**RE: 3030 Todos Santos NW
Grading & Drainage Plan
Engineer's Stamp Date: 12/6/25
Hydrology File: G10D029J
Case # HYDR-2025-00434**

Based upon the information provided in your submittal received 12/05/2025, the Grading & Drainage Plan **is not approved** for Building Permit. The following comments need to be addressed for approval of the above referenced project.

| ENGINEER'S SEAL            | <b>LOT 3 PH. 1 VOLCANO BUSINESS PARK</b><br>3030 TODO SANTOS NW<br><b>GRADING AND DRAINAGE PLAN</b> | DRAWN BY<br>DEM      |

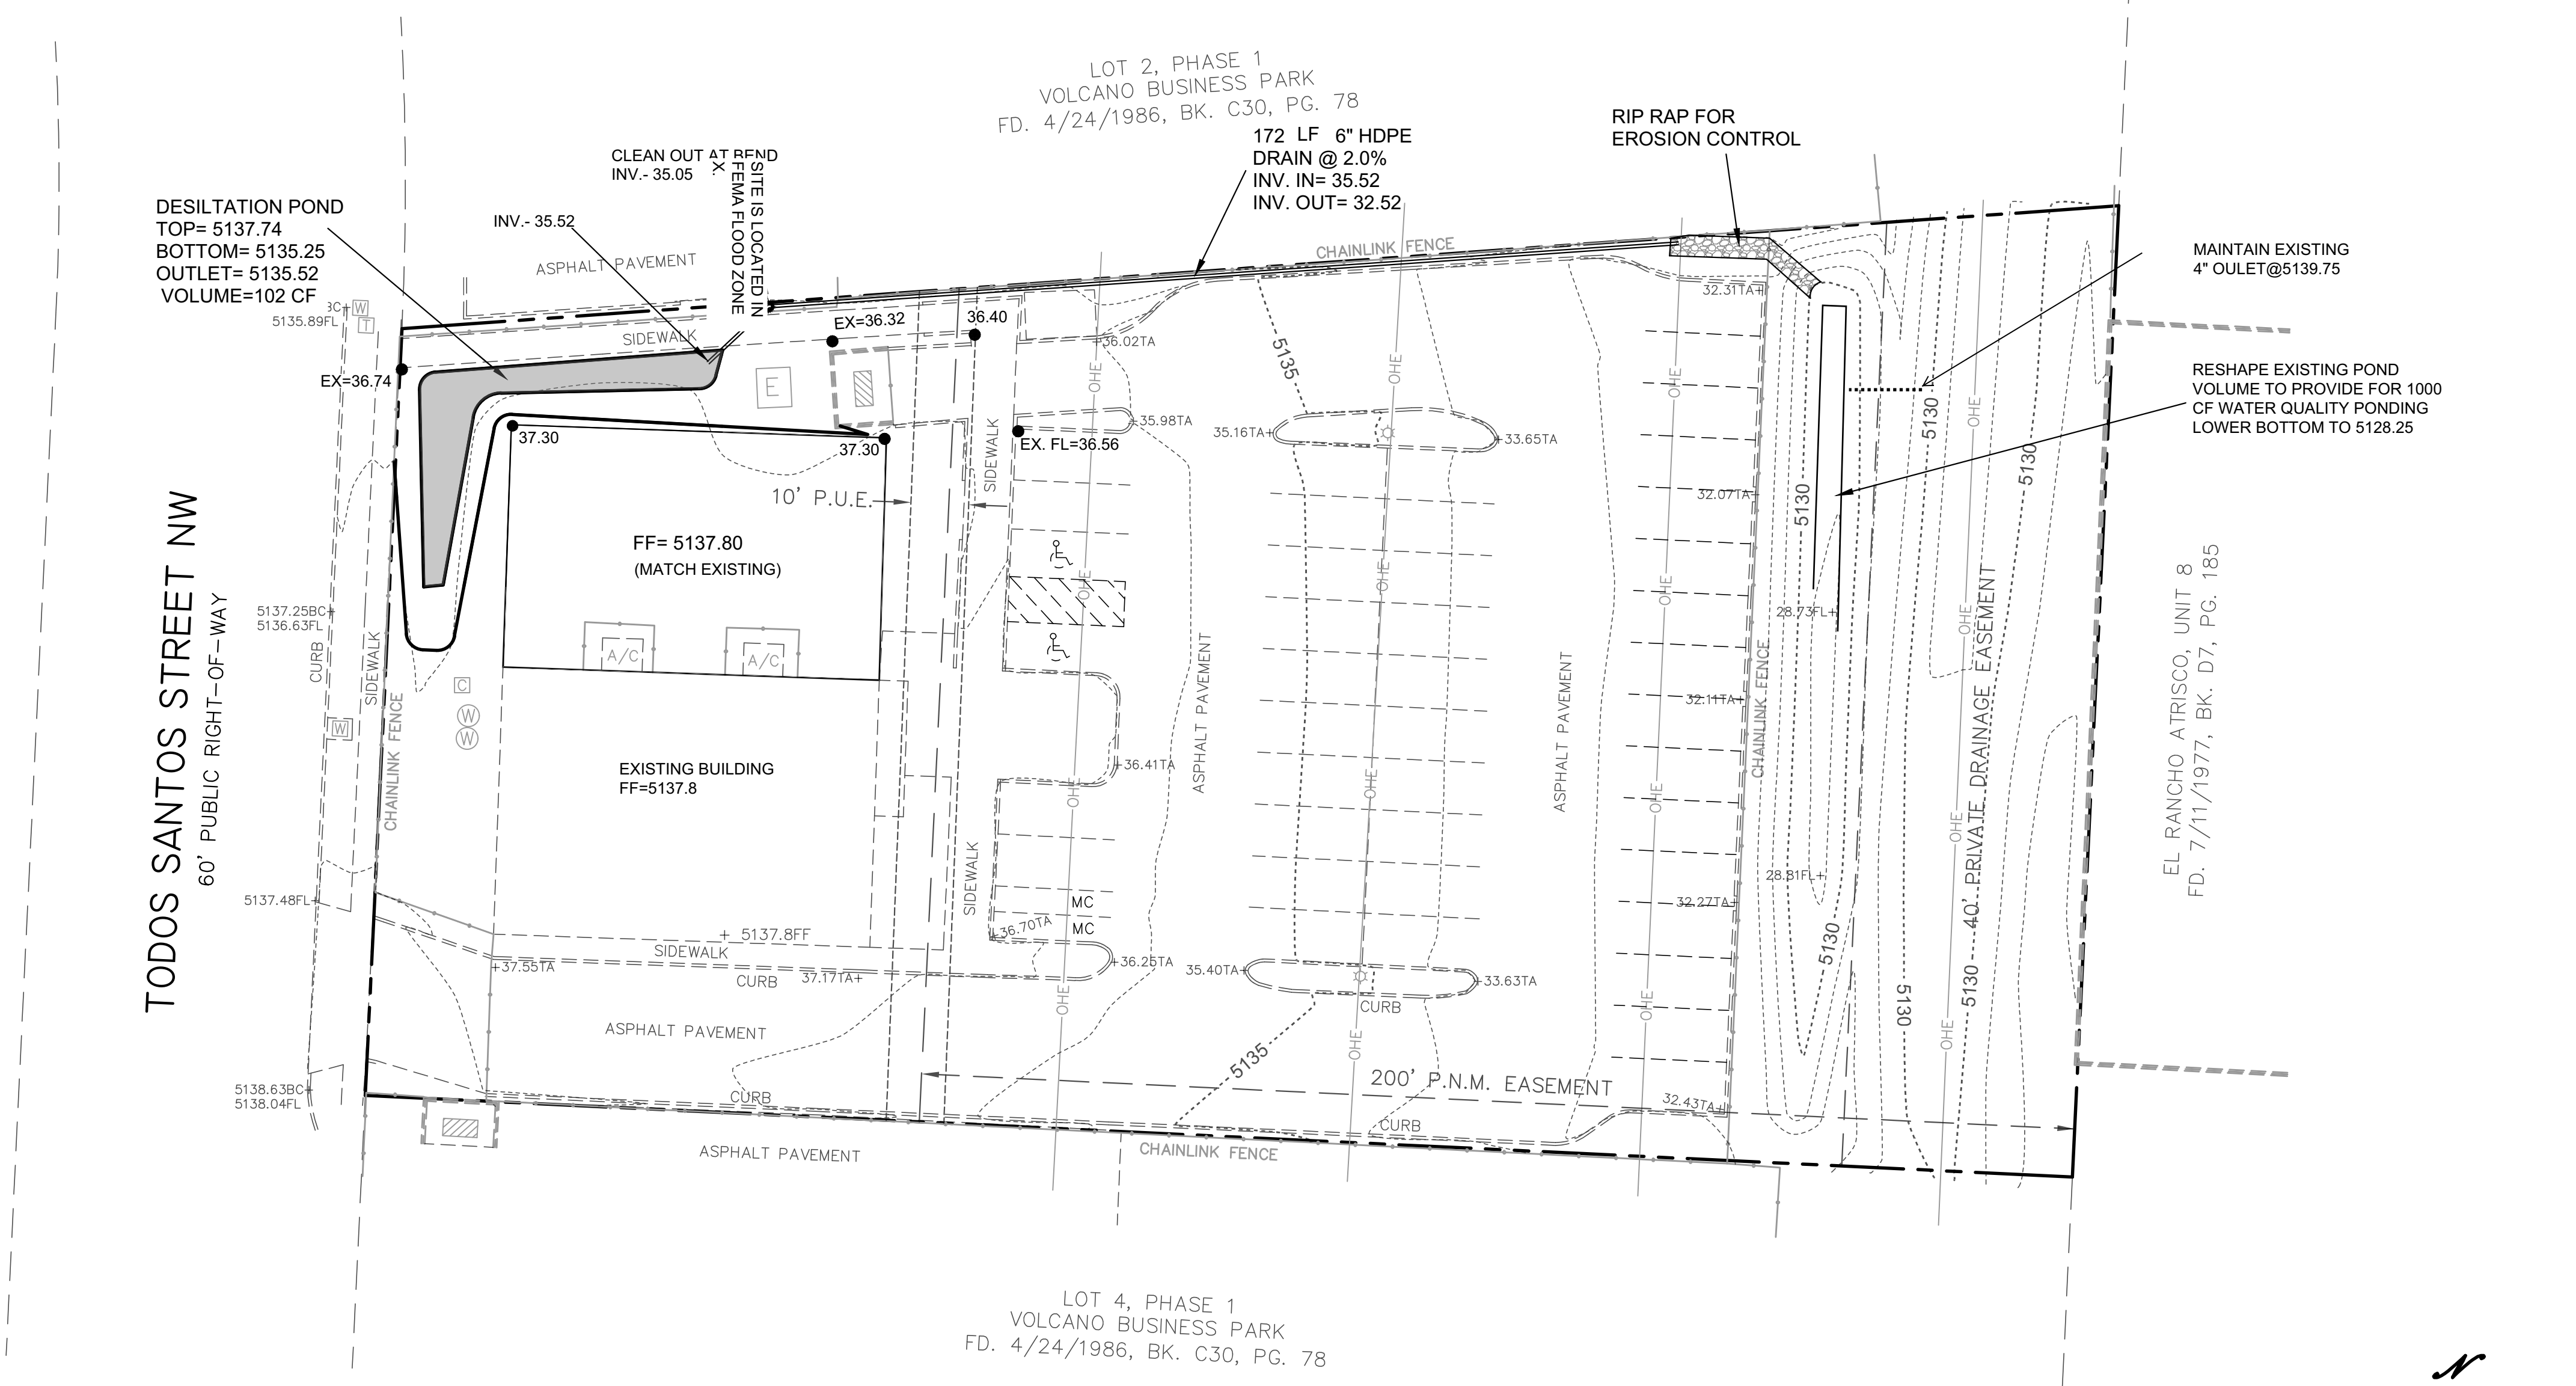
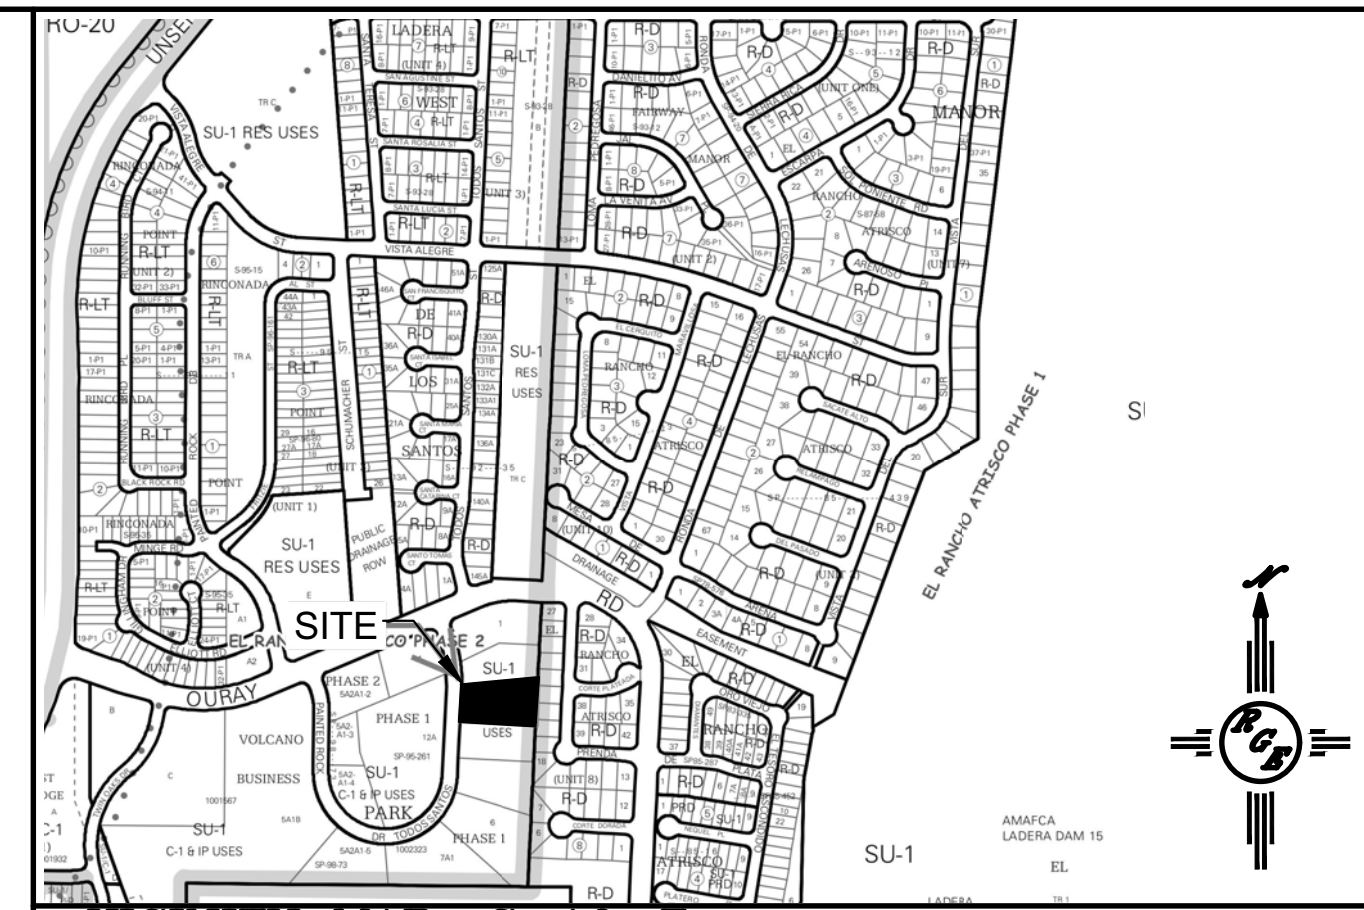
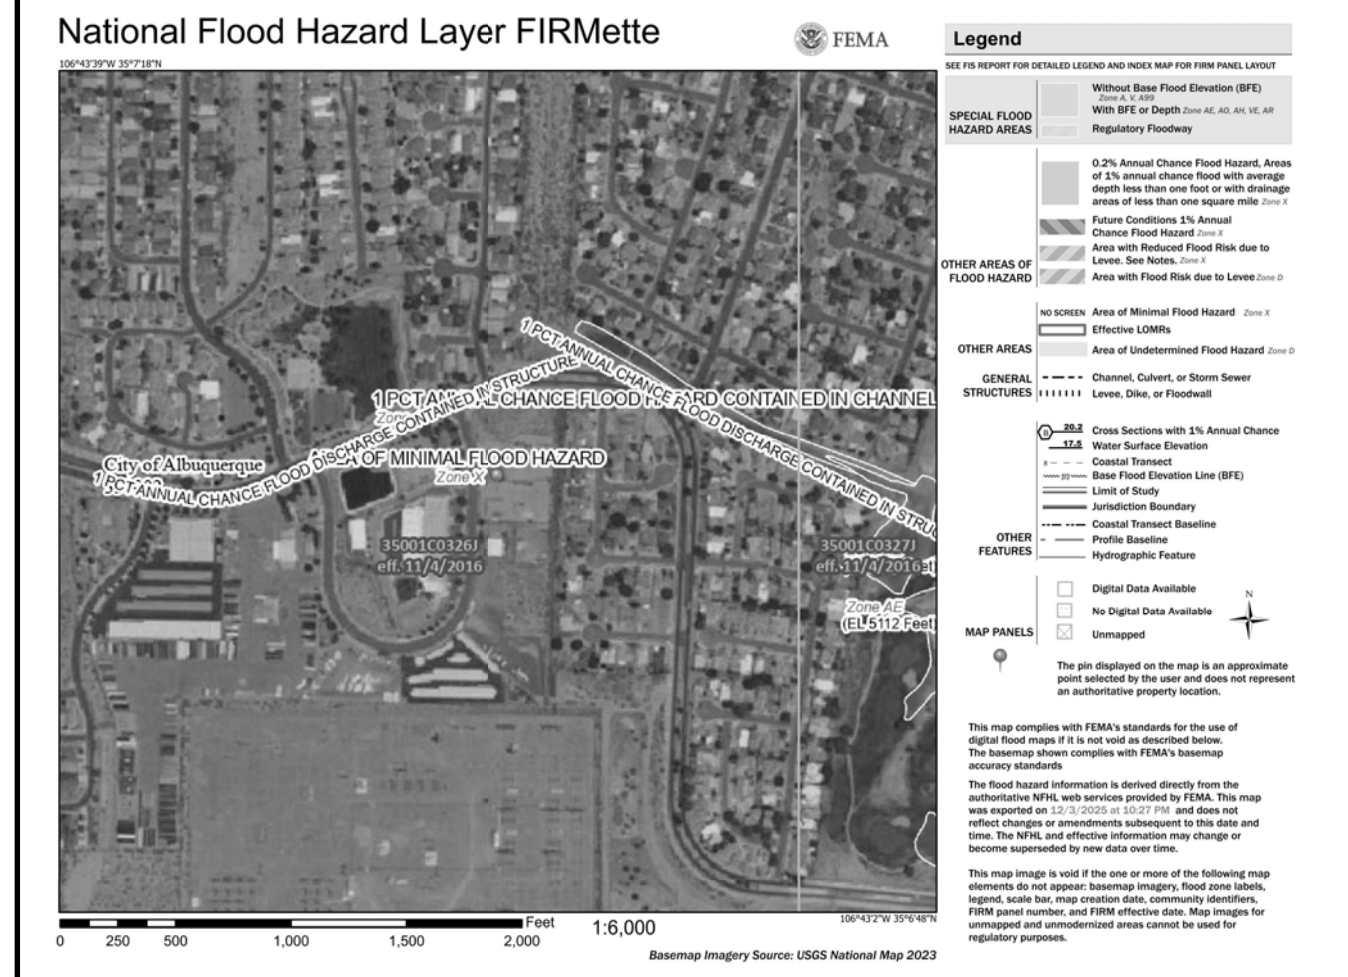
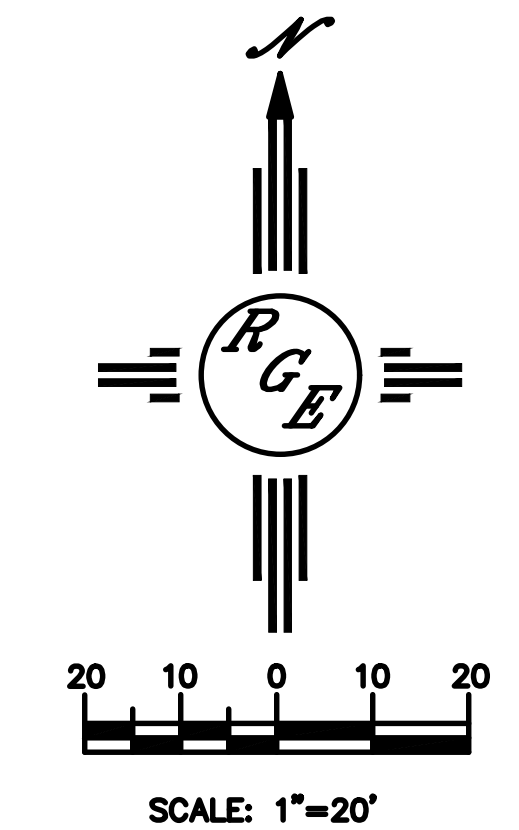
1. Please show the Existing Land Treatment types on the table.
2. Please add the floodplain note to the plan.
